REQUEST	Current Zoning: R-12MF(CD), multi-family, conditional district Proposed Zoning: B-D(CD), business distributive, conditional district and O-1(CD), office, conditional district
LOCATION	Approximately 7.11 acres located on the north side of Ballantyne Commons Parkway between Rea Road and Williams Pond Lane.
CENTER, CORRIDOR OR WEDGE	Center
SUMMARY OF PETITION	This request would allow the development of a self storage facility with up to 93,000 square feet of self storage space and an office component with no less than 7,800 square feet of office space, but not to exceed 10,500 square feet. The request also includes up to seven additional buildings for office development. The overall office square footage for the site including the component within the self storage building would not exceed 77,800. The total allowable square footage being requested including the self storage component and office use is 170,800.

PLANNING STAFF REVIEW

SITE PLAN

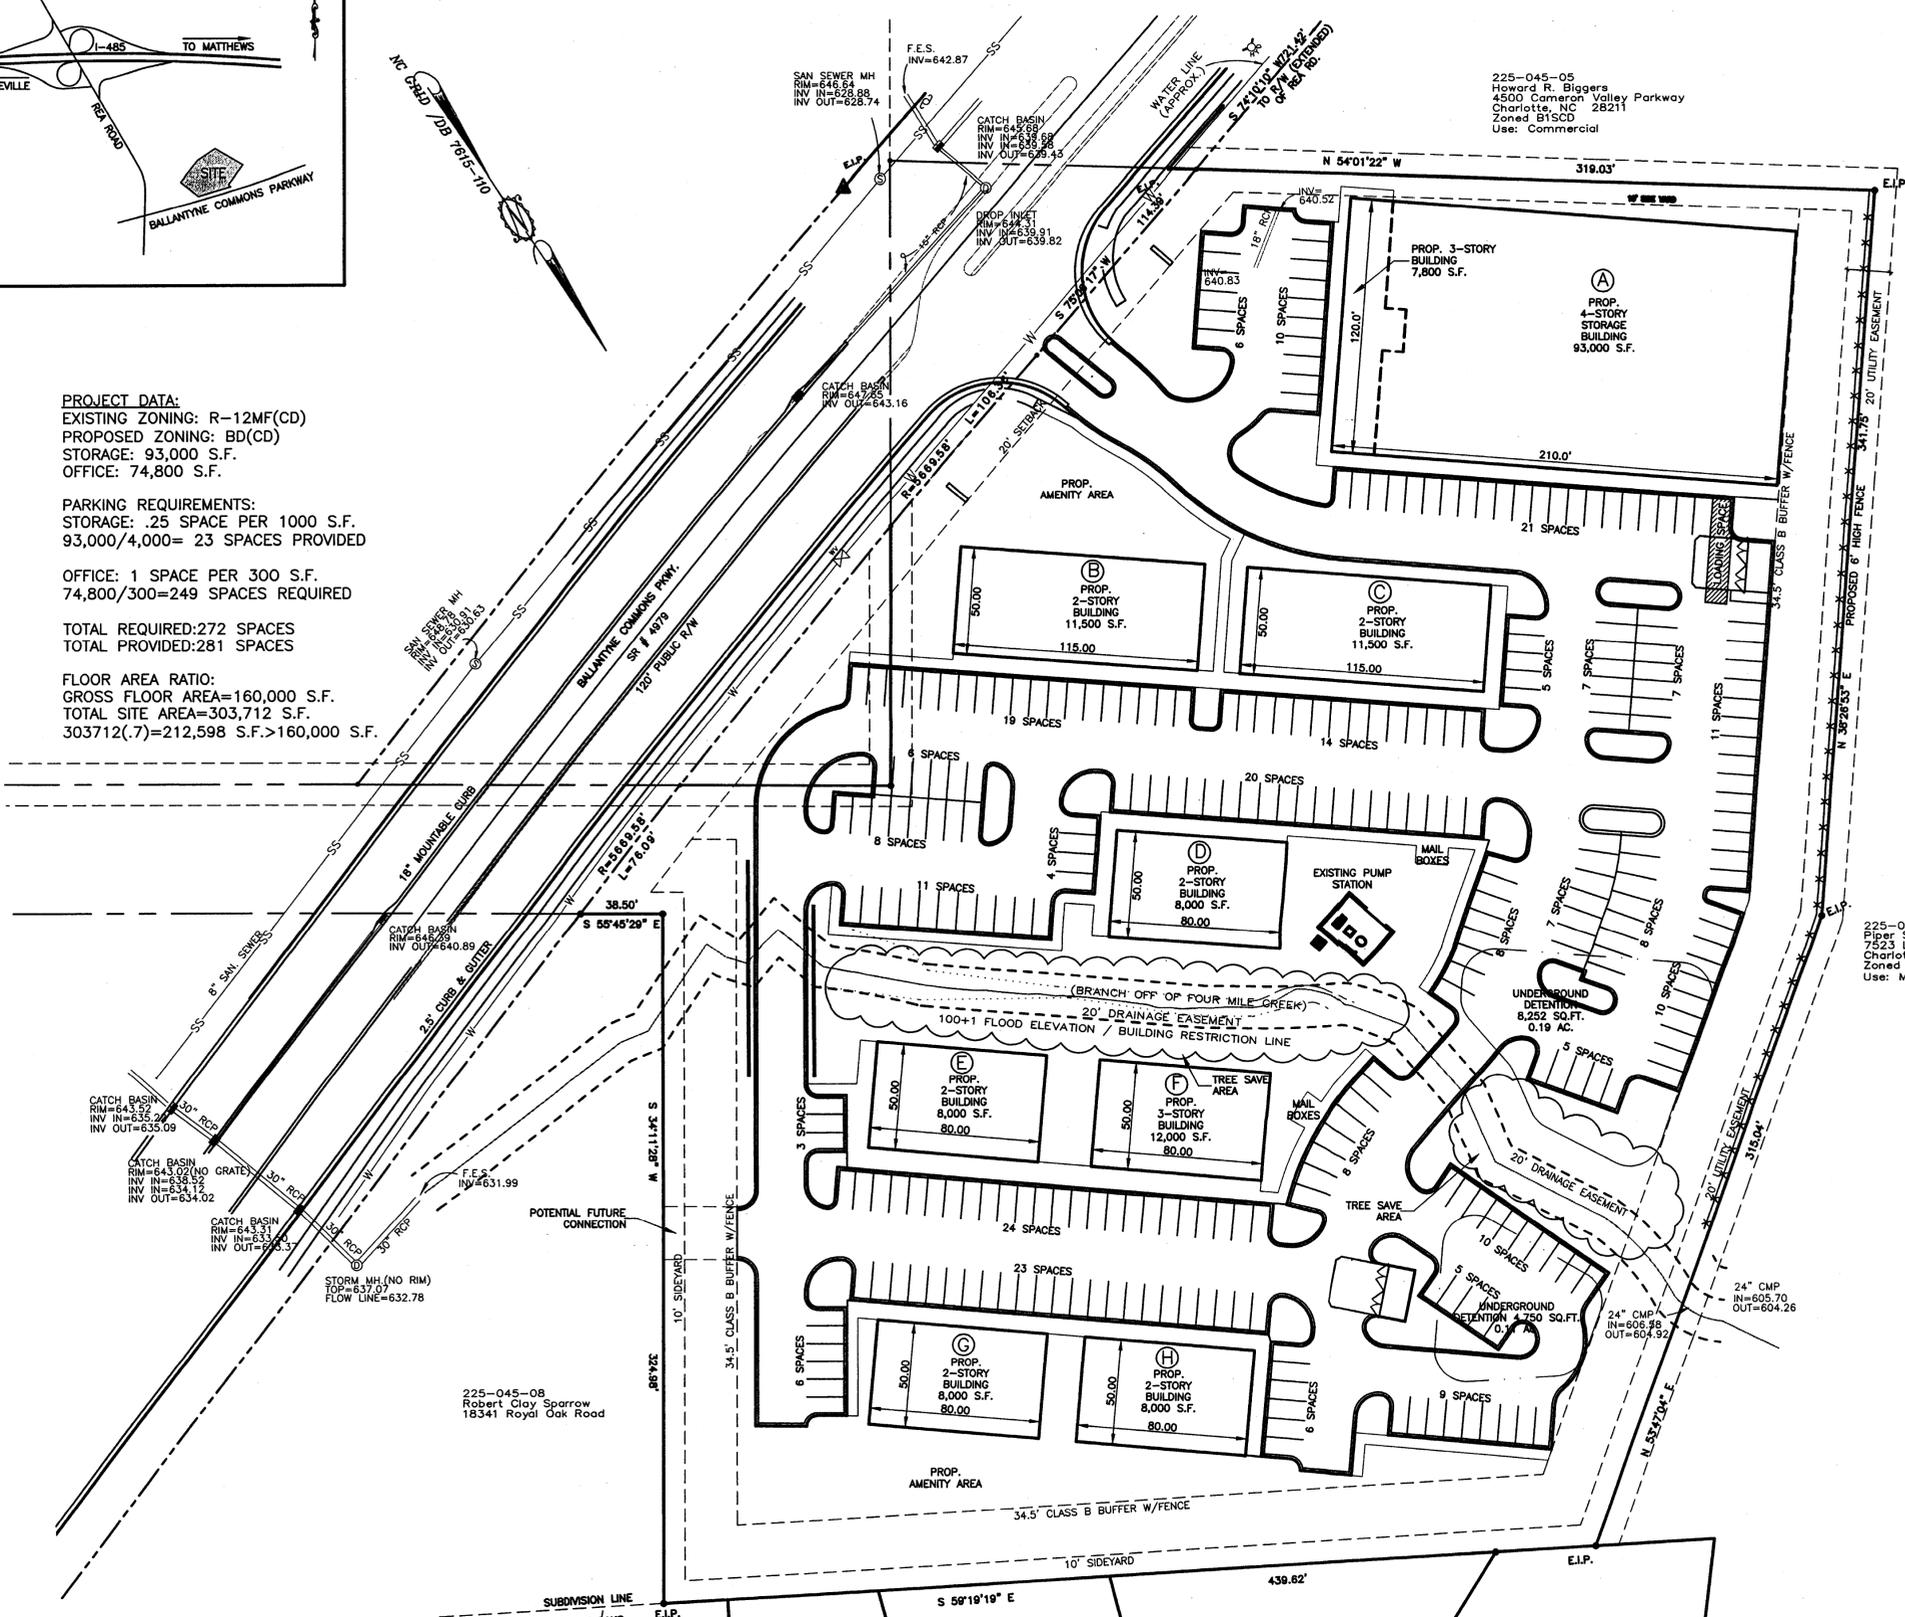
- The request includes plans "A" and "B". Plan "B" shows a larger footprint for building "B" and the relocation of the existing pump station to east side of building "C".

1. The petitioner should incorporate the proposed options shown on plan "B" into plan "A" and eliminate plan "B".
 2. The petitioner should submit building elevations that reflect the four and three story buildings reflected in the site plan notes.
-
